Proposed Balcony at 5 The Old Slipway, River Rd, Arundel

I am the owner of 2 The Old Slipway, River Rd. This is the ground floor flat with the only terrace looking onto the river. I object to the planning application for the following reasons:

DRAWING
Second Floor Plan + Elevations
as Proposed

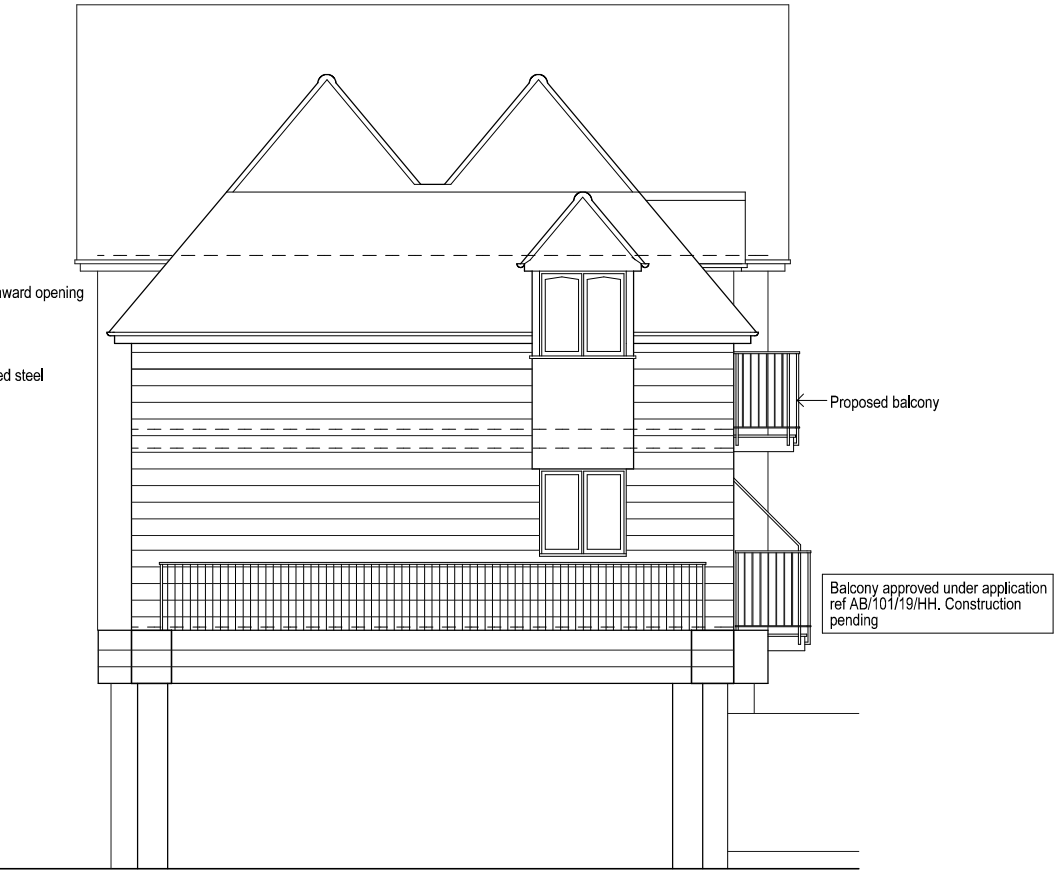
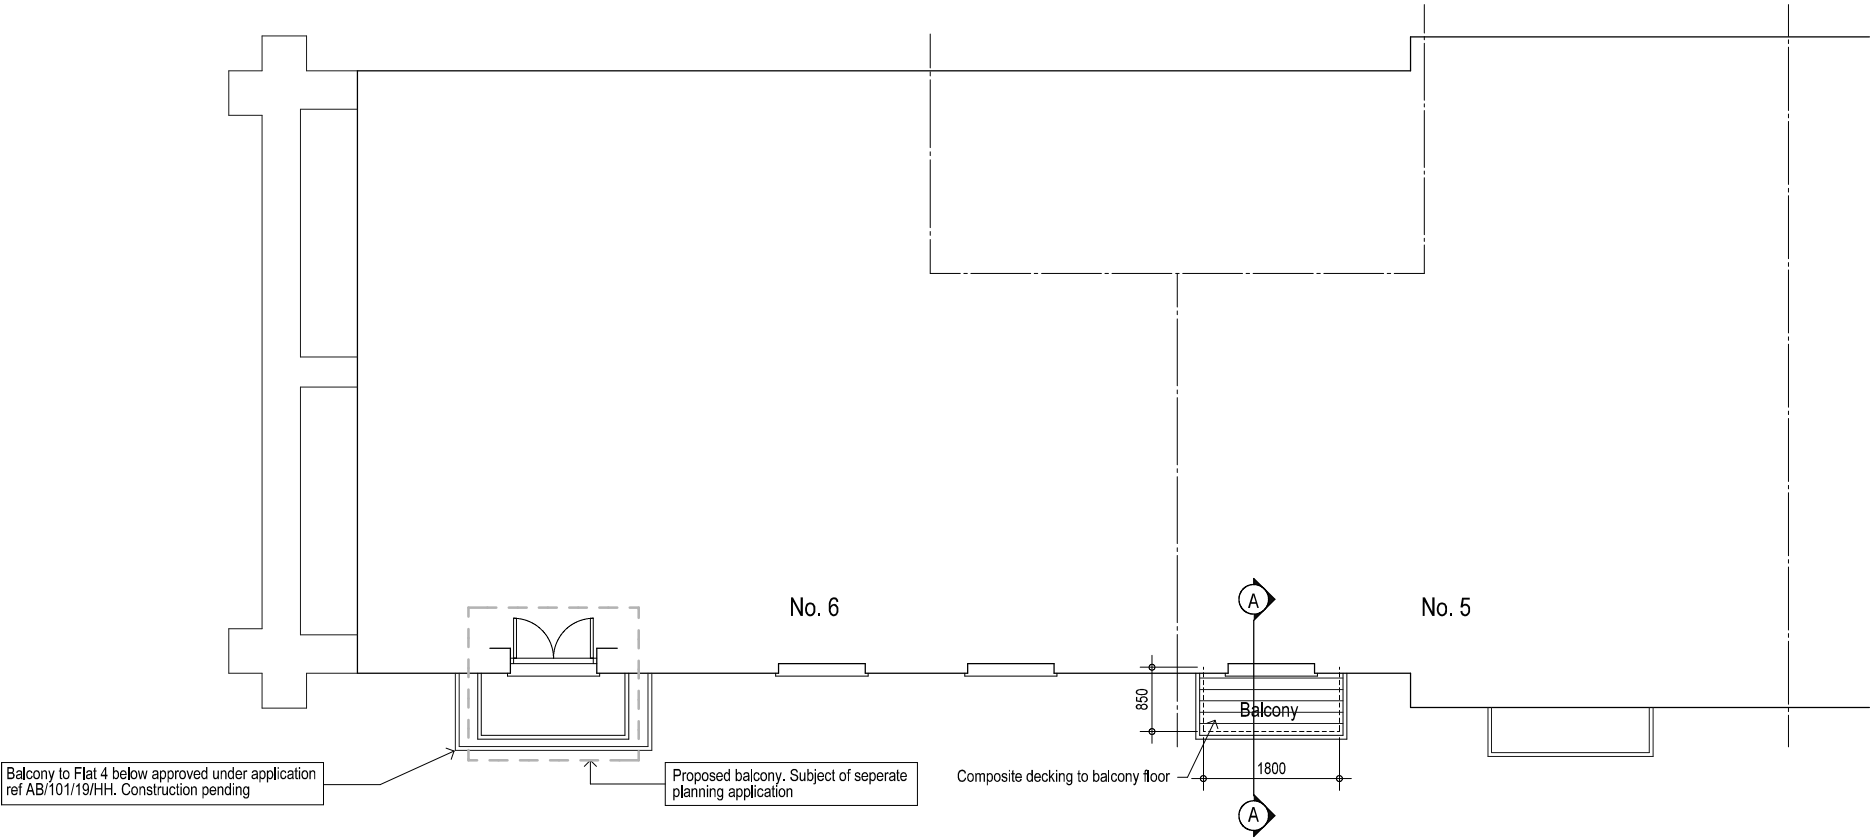
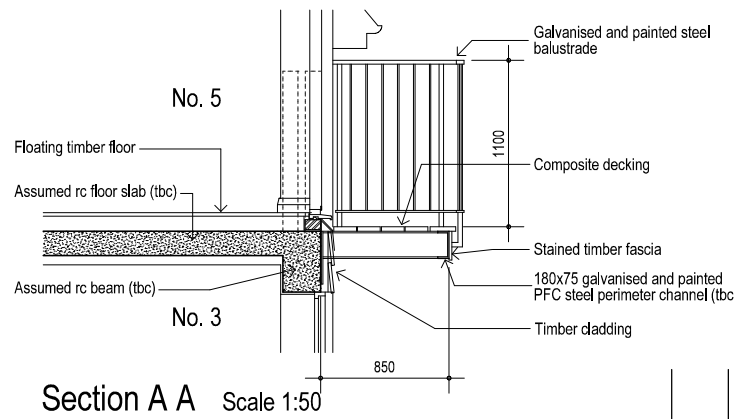
1. Loss of Privacy. This balcony will be directly above our terrace, on the second floor. This would significantly inhibit the enjoyment of our terrace by directly overlooking us. Although there is a small element of overlooking from the window that is there currently, by increasing the size and opening together with the physical structure of the steel balcony, the issue for being overlooked is greatly increased. There is a huge difference between someone looking out of a window and someone physically being on a balcony immediately above our terrace.

2. Detrimental effect upon the Character and Appearance of the Building from my terrace and the river. This elevation is clearly visible from my terrace and the river and by removing the existing window and a portion of the wall below cill level, installing inward opening French doors, and adding a steel balcony, it would detract from the character and appearance of the building and that of the Arundel Conservation area. It would also be overbearing having a steel structure at that height.

3. A previous application for a Juliet balcony was rejected and one reason was that it would create an unbalanced appearance on that elevation. In the Design and Access Statement it states that a future matching application for flat Number 6 counters this. I disagree and feel that two changes such as this will only serve to multiply the detraction from the character and appearance of the building. Two such

insensitive changes would not be protecting or enhancing the visual amenities and environment of the area. It would also increase the lack of privacy to my terrace.
